Our Ref: 21/00013/HOU

LOCATION: Garages between 84 and 86 Francis Avenue, Southsea, PO4 0HP

PROPOSAL: Construction of garage following demolition of five existing garages, and resurfacing of shared access road **(21/00013/HOU)**

PROJECT	
Garages between 84 and 86 Francis Avenue, Southsea, PO4 0HP	
DRAWING TITLE	Location Plan
DATE	31.12.20
SCALE	1:1250 @ A4
DRAWING NAME	GCS
REVISION	A

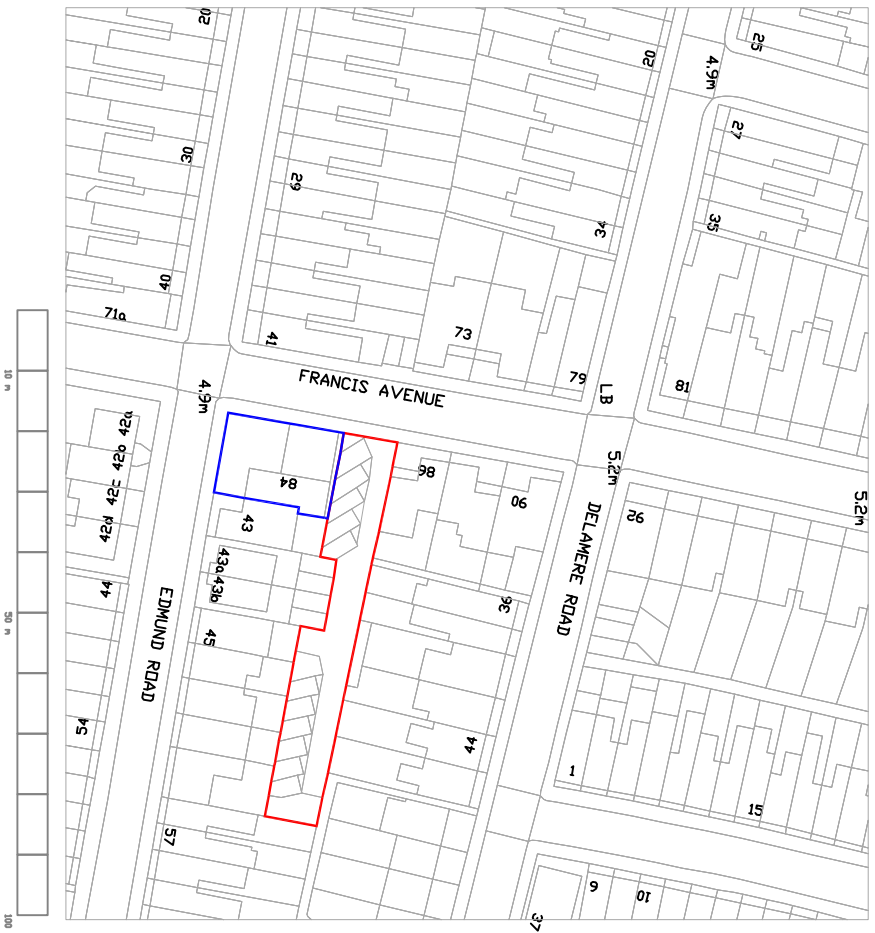
4) Location Plan

Under Section 107 of the Copyright, Designs and Patents Act 1988 makes it a statutory requirement that a person must not distribute an unlicensed Ordnance Survey Plan. The unauthorised reproduction and the processing of unlicensed plans

is an infringement of Crown Copyright and could amount to an offence by the person submitting the plan. You therefore are requested to submit authorised copies of Ordnance Survey plans, or if you hold a valid Ordnance Survey Paper Map Copying Licence please submit two copies of the site location plan with the outline of the site marked in red, clearly showing the licence number.'
